Application no: H19/0424/98

Location: Pt OS 8525, Broadgate Road
Sutton St Edmunds
Spalding
Lincs

Amendment: As built - plans for farm buildings
Dwg.Nos. SM.02B; WD1890/1A & /1B

TOWN AND COUNTRY PLANNING ACT 1990
NOTICE OF ACCEPTANCE OF AMENDMENT

DRAWN: R. W. VINCENT	JOB No. MS 150/1
DATE: 16/12/99	
REVISIONS	
Main Scale: 1/75	DRAWING No. WD 1890/12
Drawn Scale:

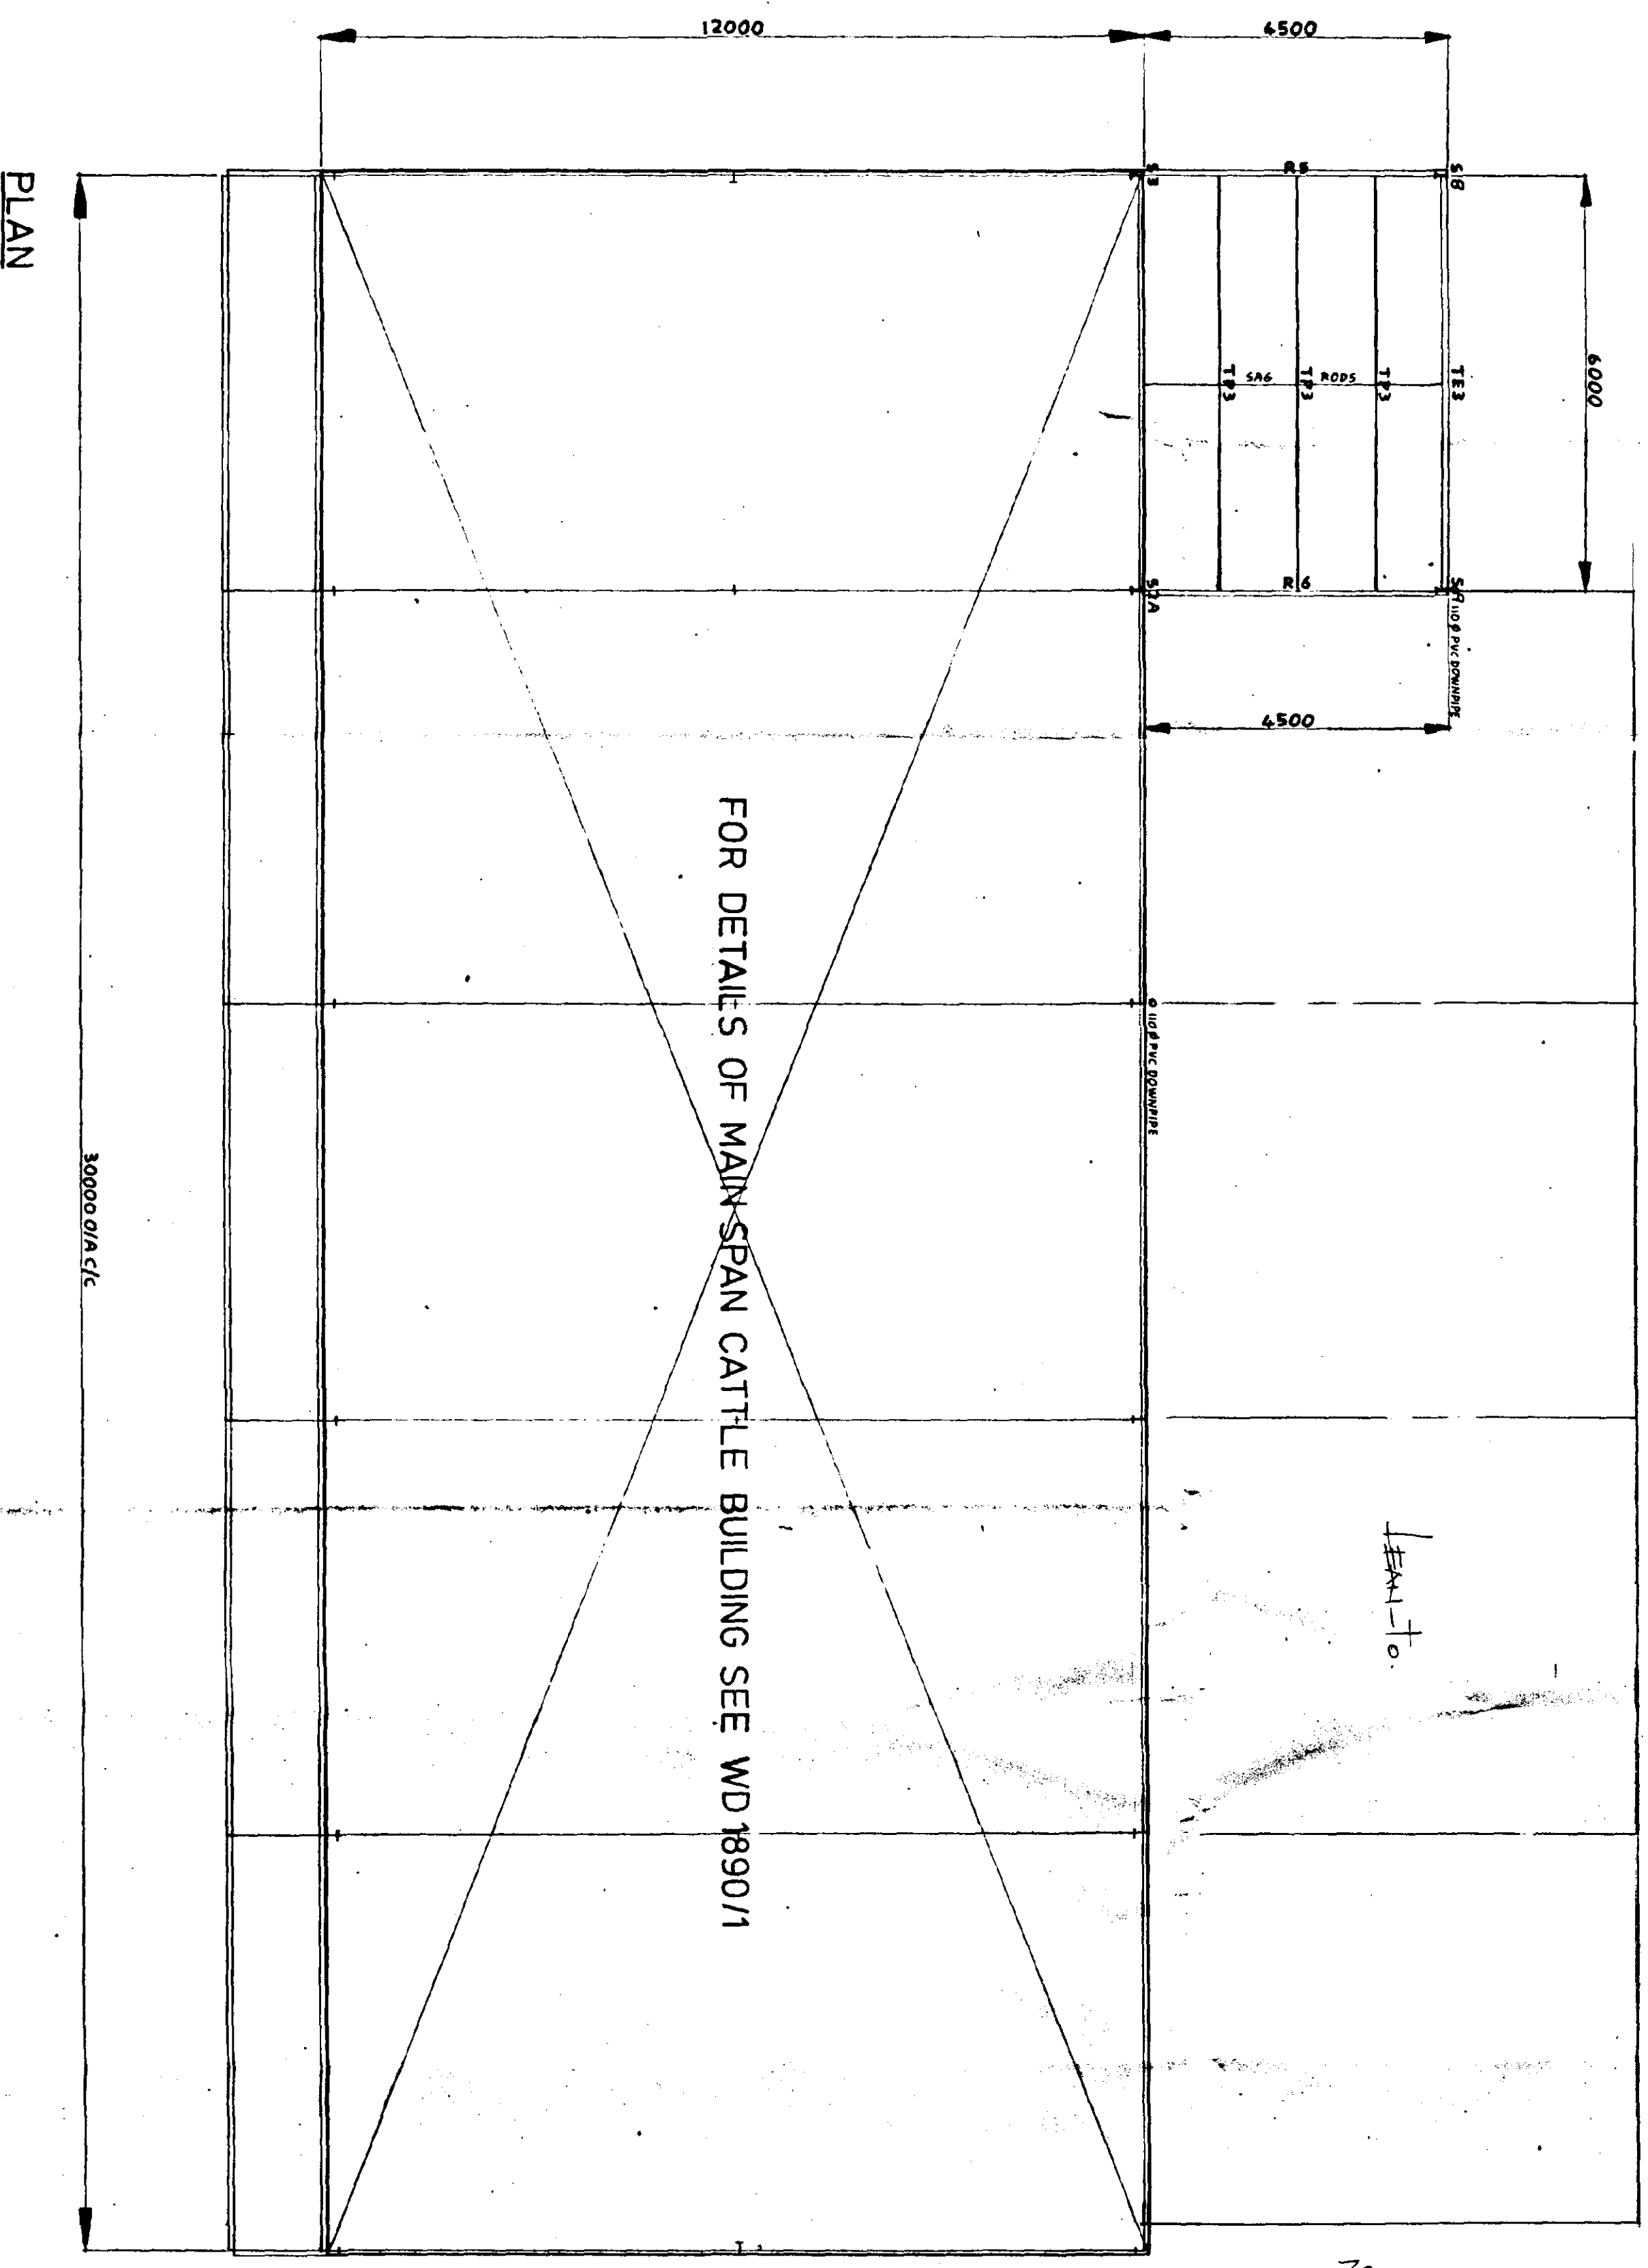
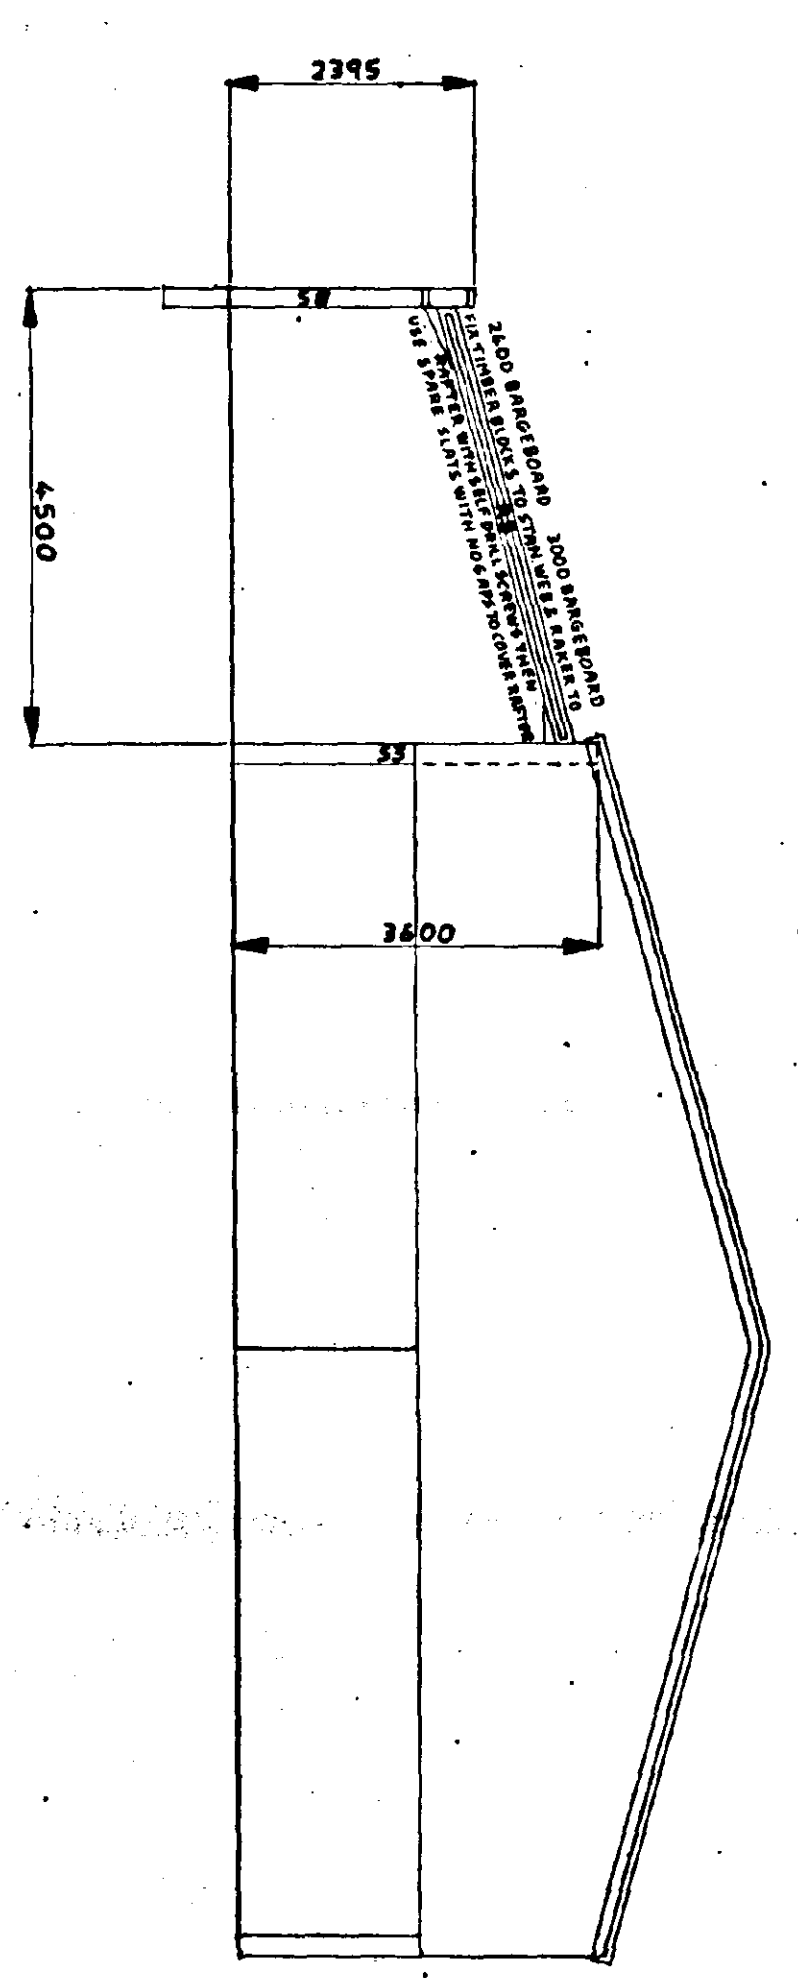
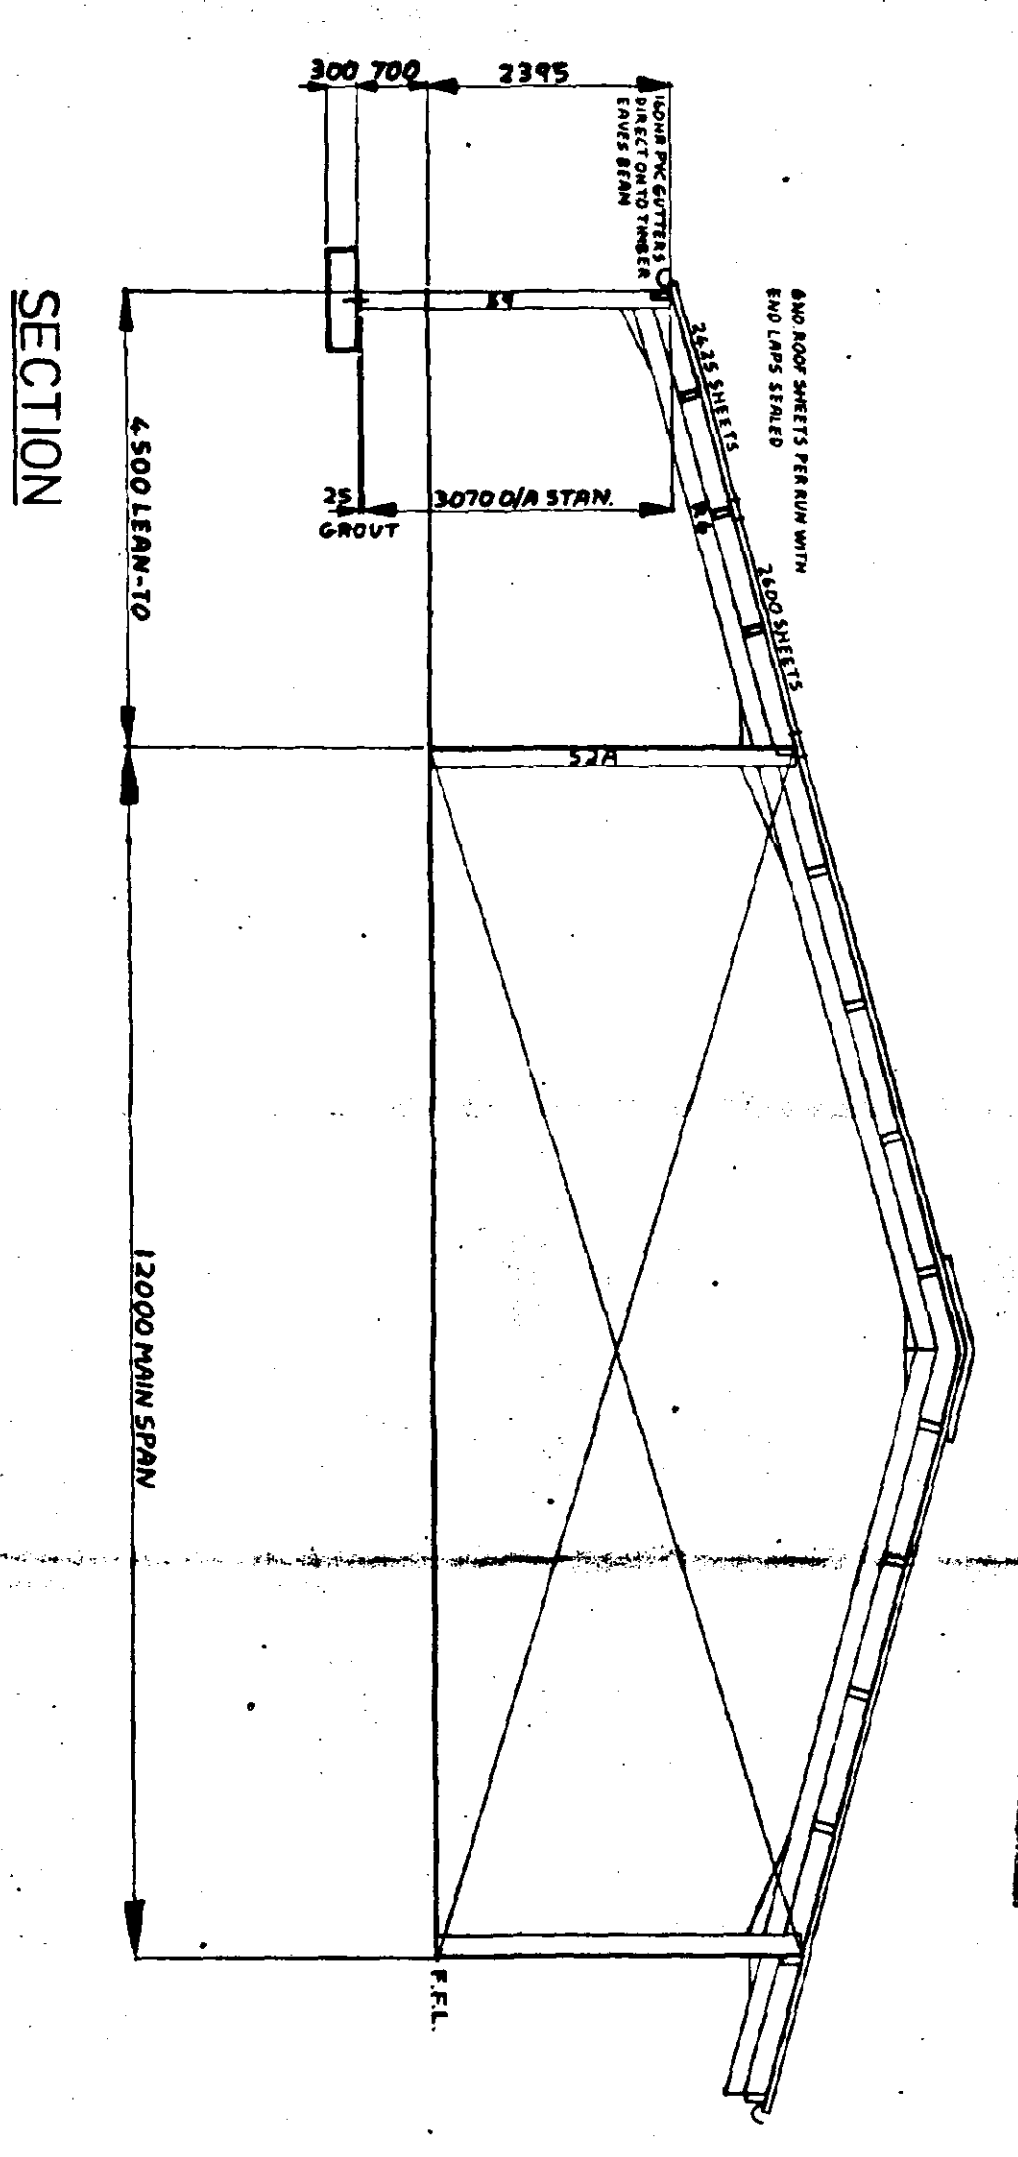
Amendment: Amended cattle building
Dwg nos. SM.02A, WD1890/1A & WD1890/12

The amended details submitted in respect of the above proposal have been received and I consider that the changes are too significant to be treated merely as an amendment. A fresh application will therefore be required (forms enclosed). This does not imply that permission will or will not be forthcoming for any such revised application.
